Plan Corrections

Plans Examiner:	<u>Paul Skidmore</u>	Phone:	<u>(206) 275-7718</u>
Permit Number:	<u>2012-149</u>		
Project Name:	<u>Barnett Remodel</u>		
Contact Person:	<u>Josh Peterson</u>	Project Number:	<u>A20-010</u>
Date:	<u>10/26/2021</u>	Phone:	<u>509-710-2374</u>

Per your correction notices dated September 28, 2021:

MAIN FLOOR PLAN  
SCALE: 1/4"=1'-0"  
A20-010 A2.1.dwg

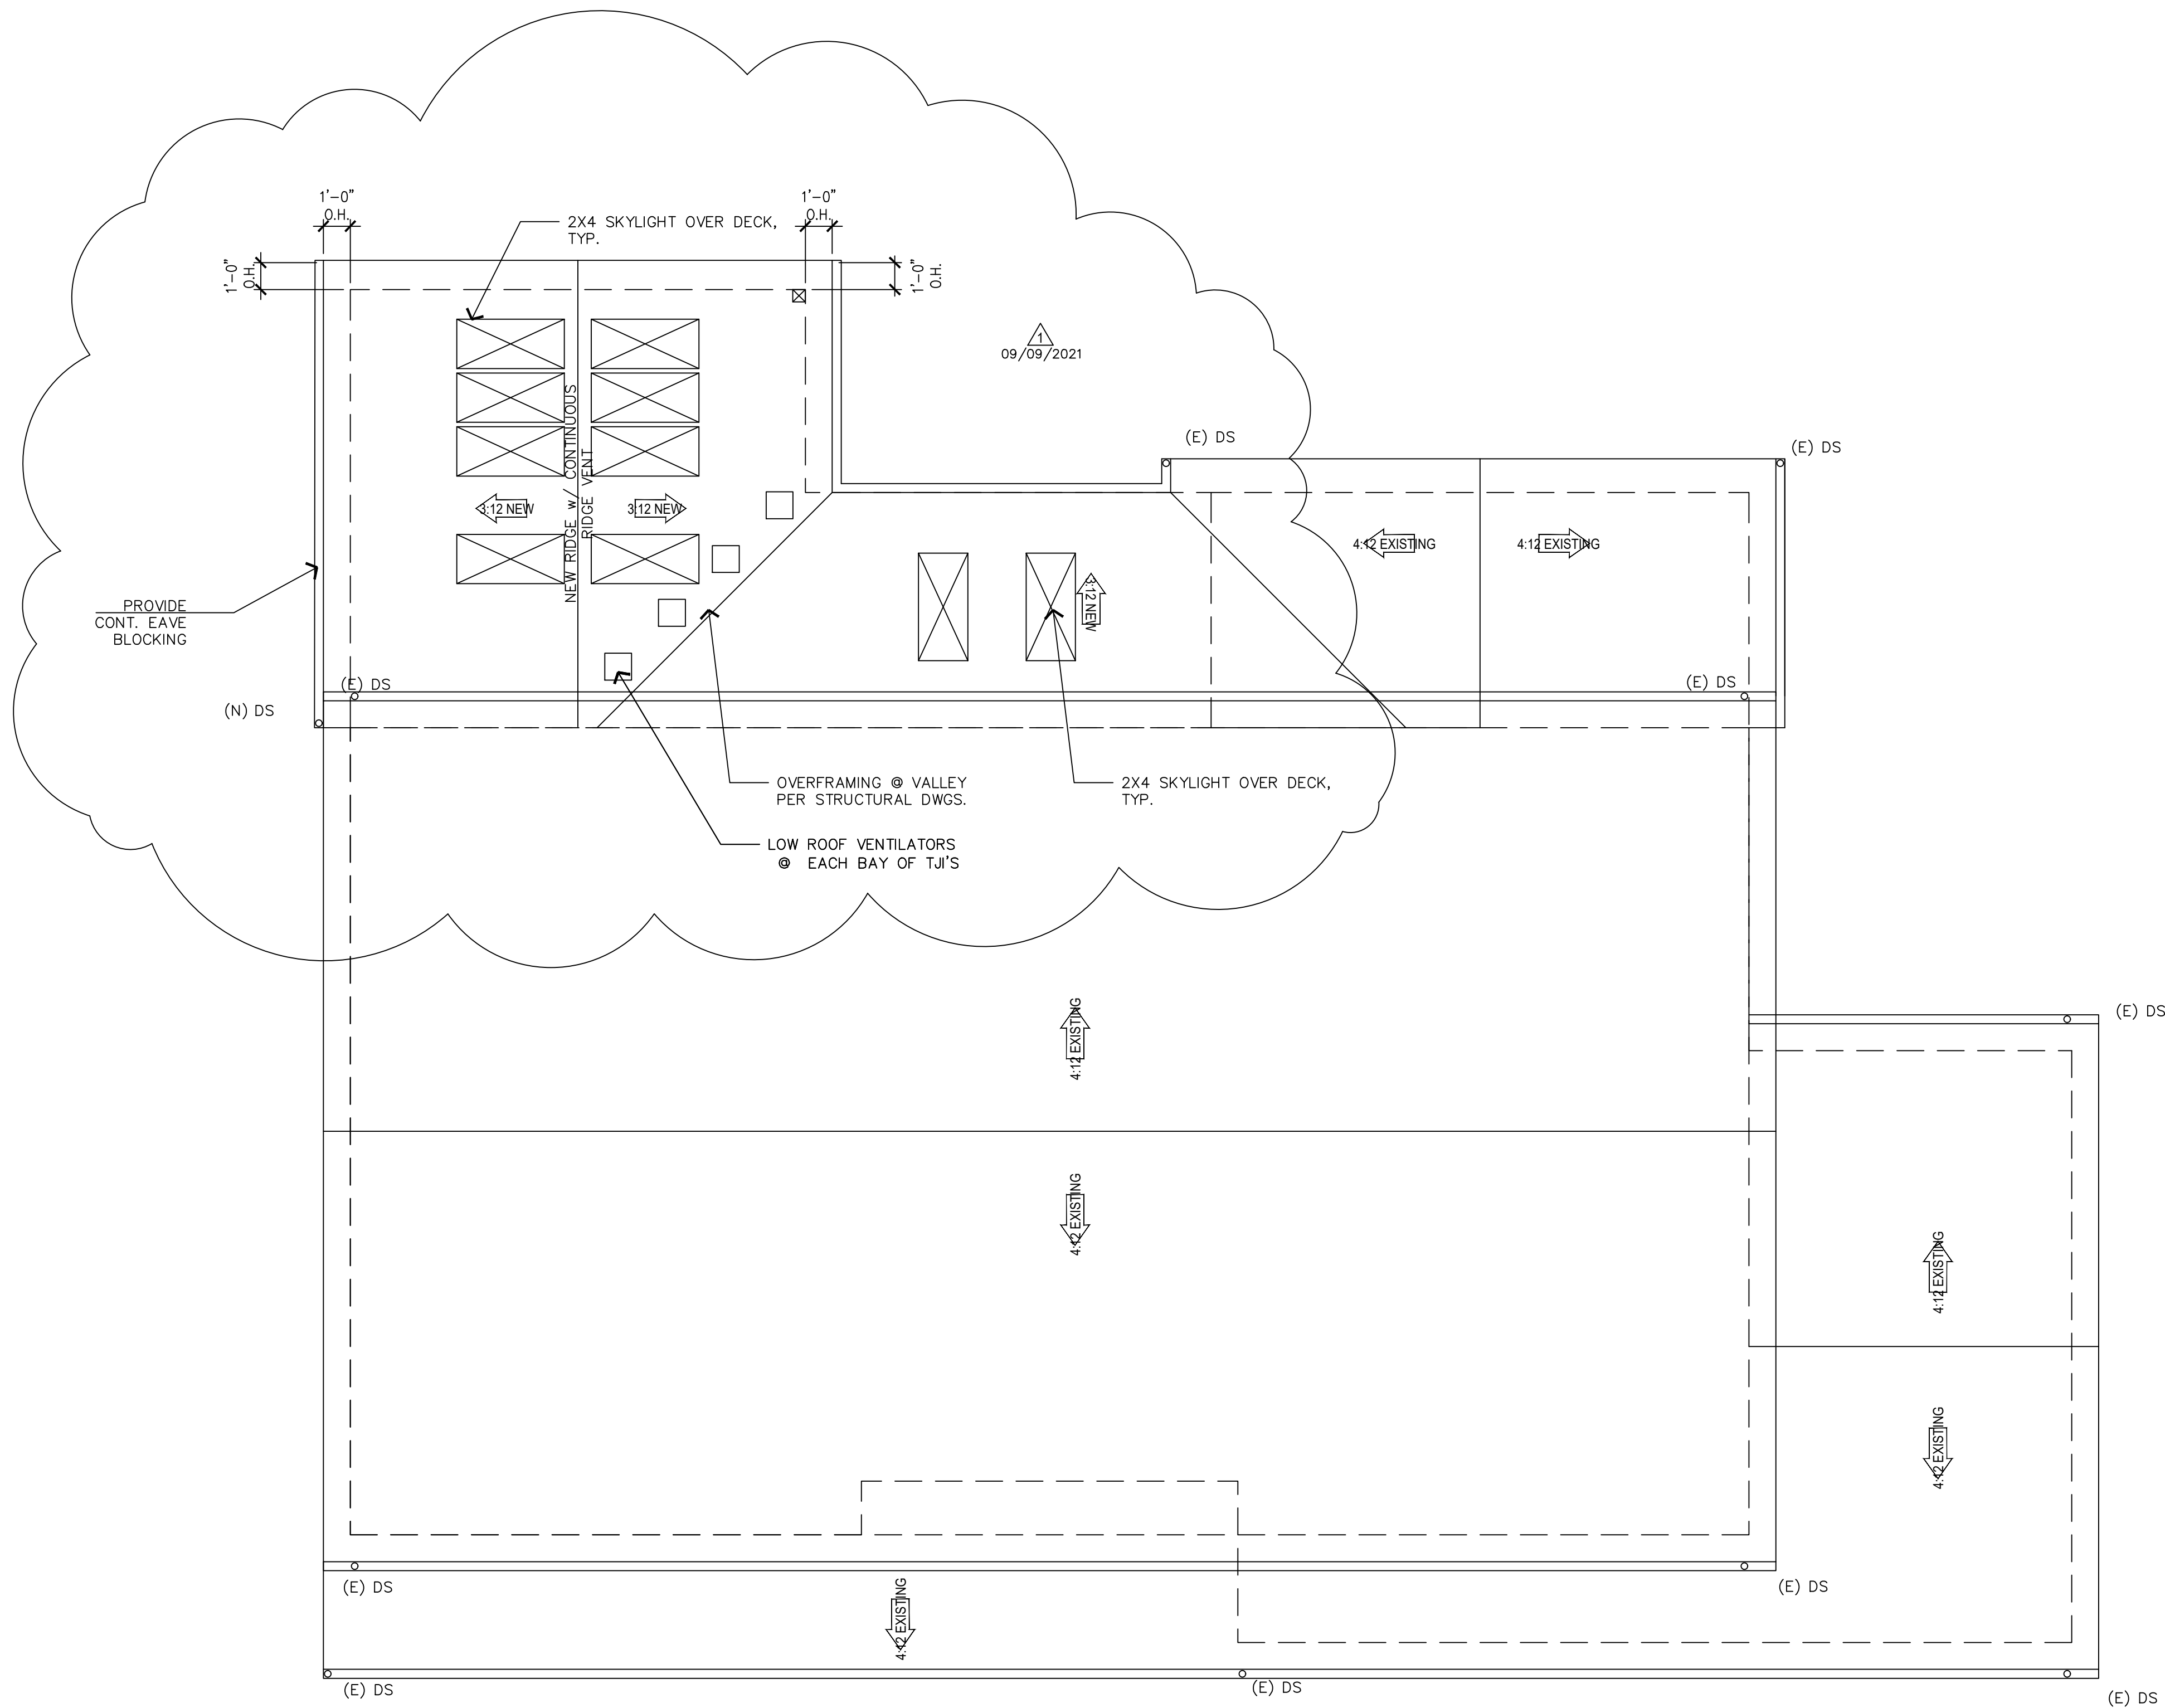
1. A2.1 - Provide Automatic shut-off controls for outdoor heaters.
R: Note has been added to plan. This is a standard feature for these heaters.
2. A2.1 - Existing ceiling, wall or floor cavities exposed during construction. Provide these cavities with insulation of full cavity. 2x4 framed walls shall be insulated to a minimum of R-15 and 2x6 walls shall be insulated to a minimum of R-21.
R: Note has been added to plan.

3. A2.1 – Please relocate and dimension the location of the footing.
R: For clarity, the footing location has been noted on the architectural floor plan.

5. Please note all beams exposed to weather shall be naturally decay resistant or preservative treated.
R: This noted has been added on Architectural Sheet A2.1

**S-3**

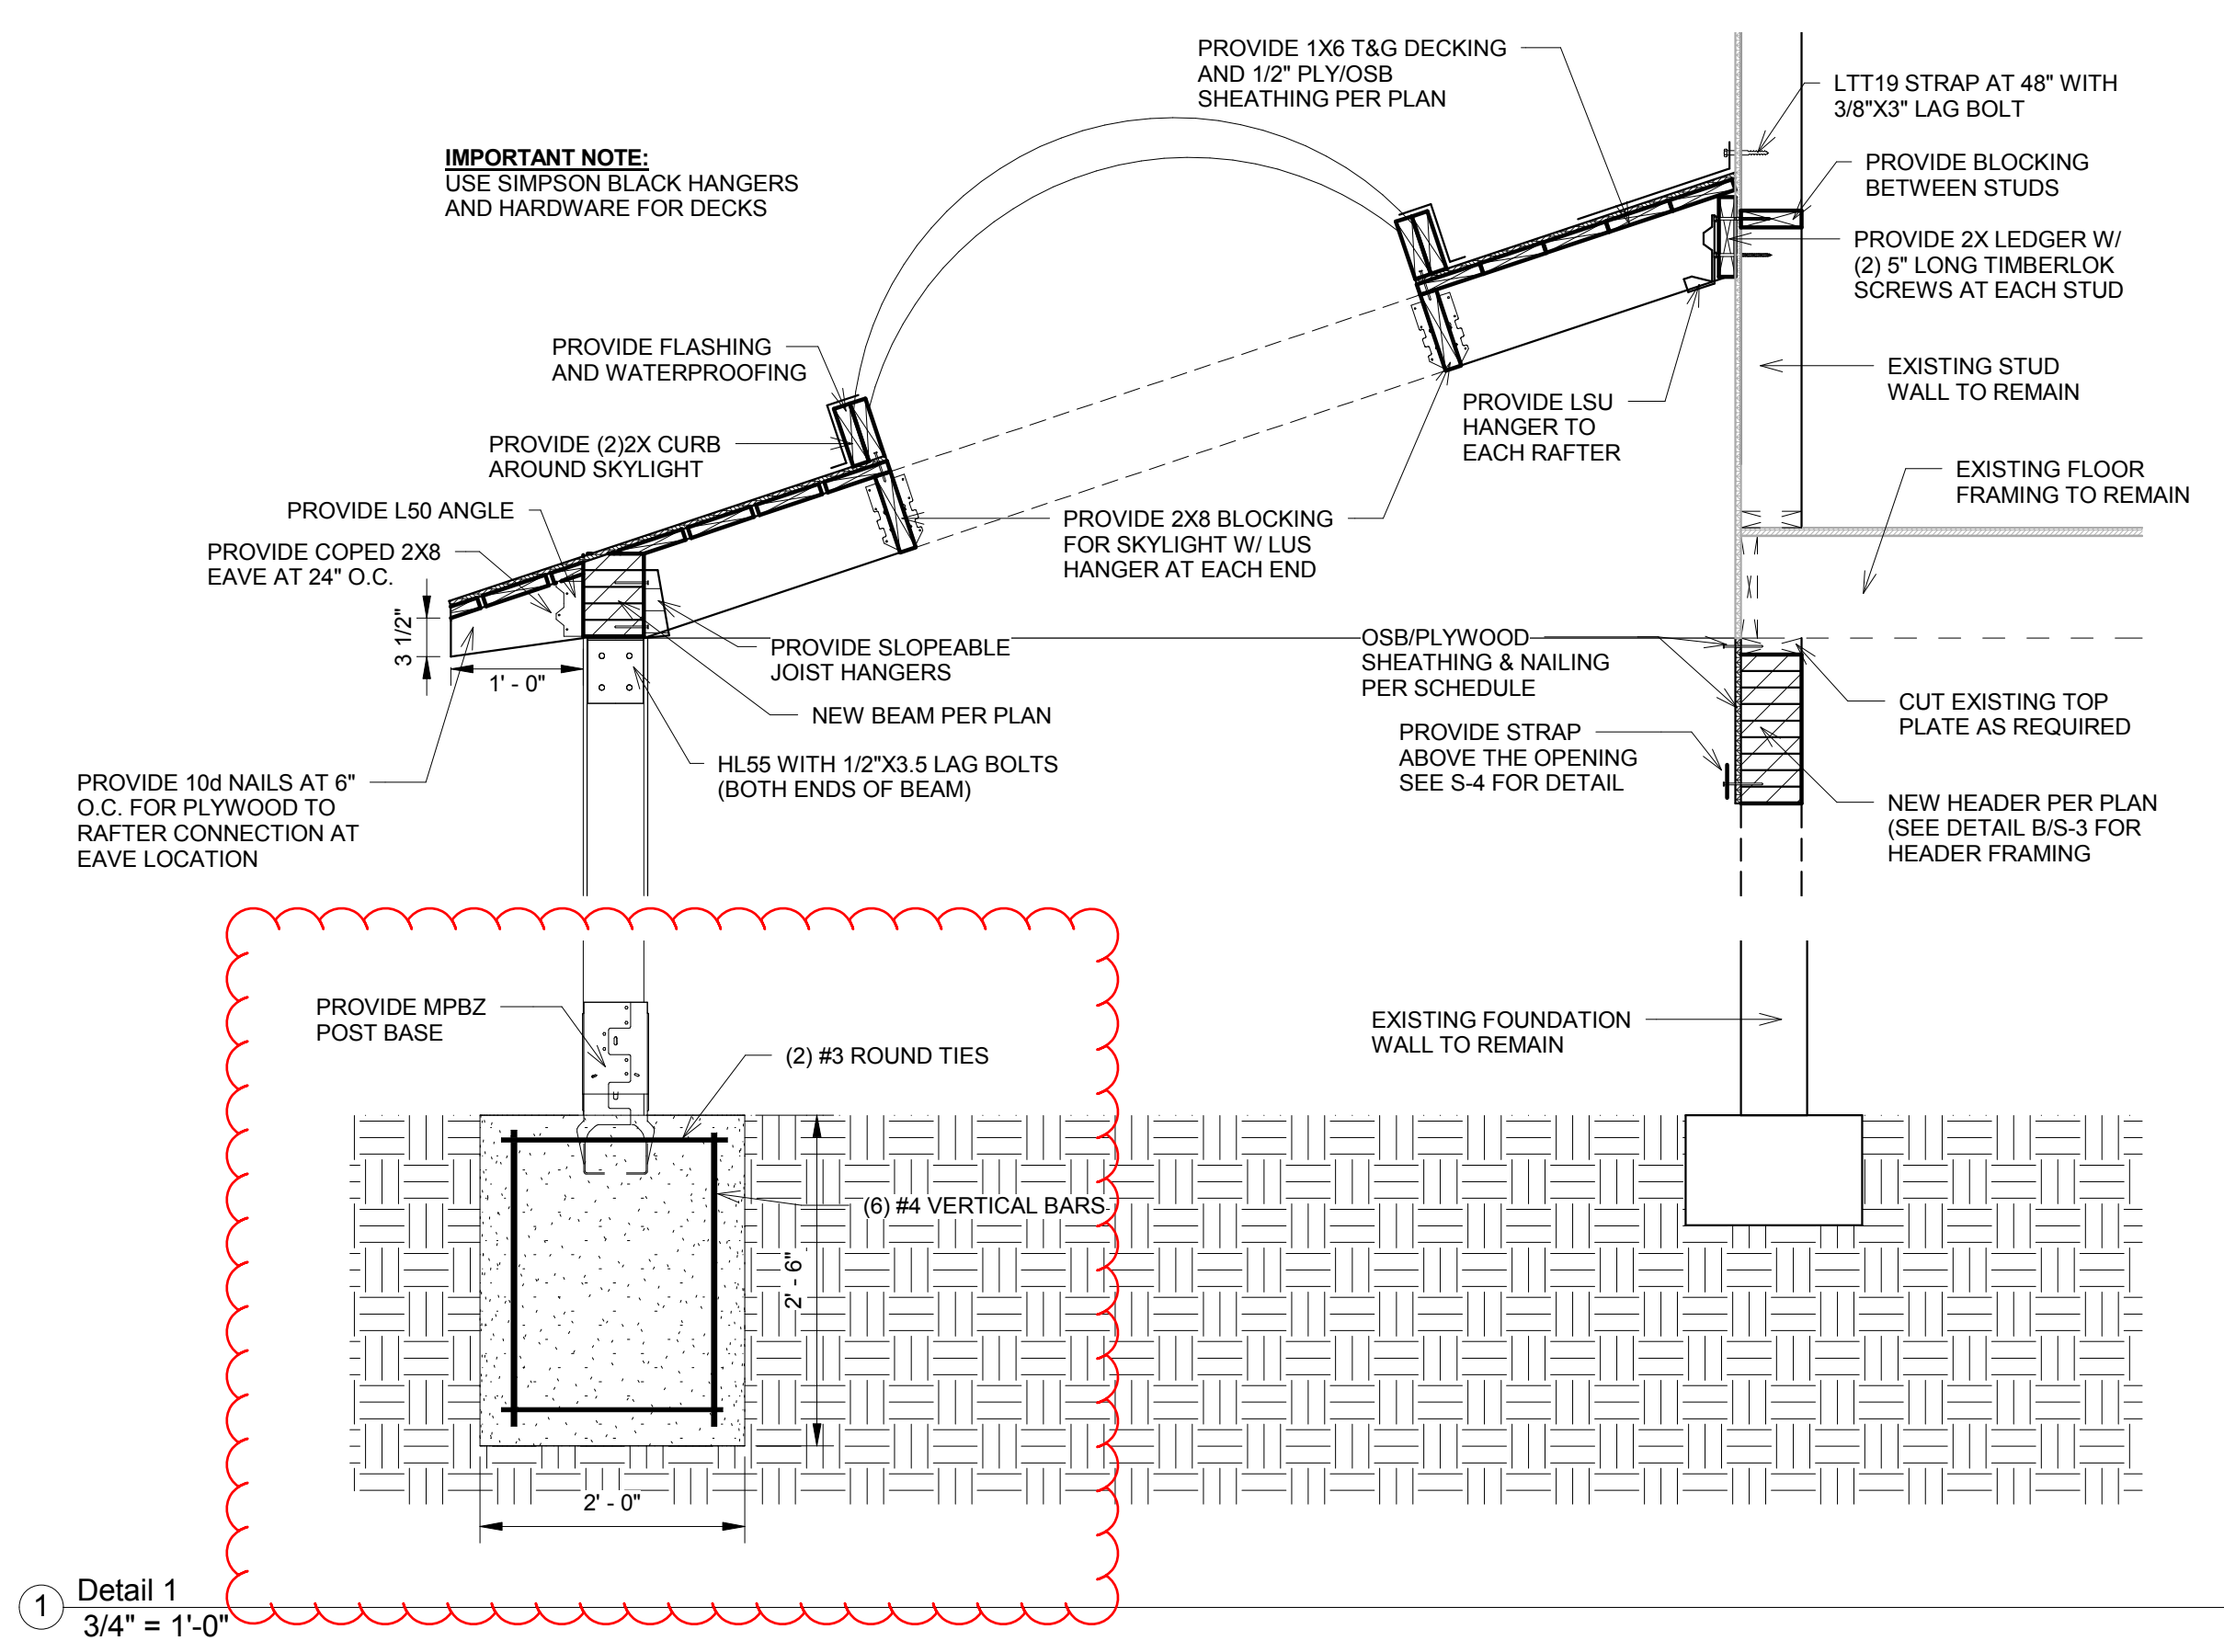
4. S-2 – Please provide method to resolve lateral forces along this line. If the diaphragm is intended to cantilever, please provide a method to resolve the rotational force resultant.
R: There are (4) cantilever 6x6 posts with simpson rigid post base (MPB66Z) to resist lateral forces along this line. Please see attached calculations for Post, Base, and Footing. Please also see updated structural drawings.
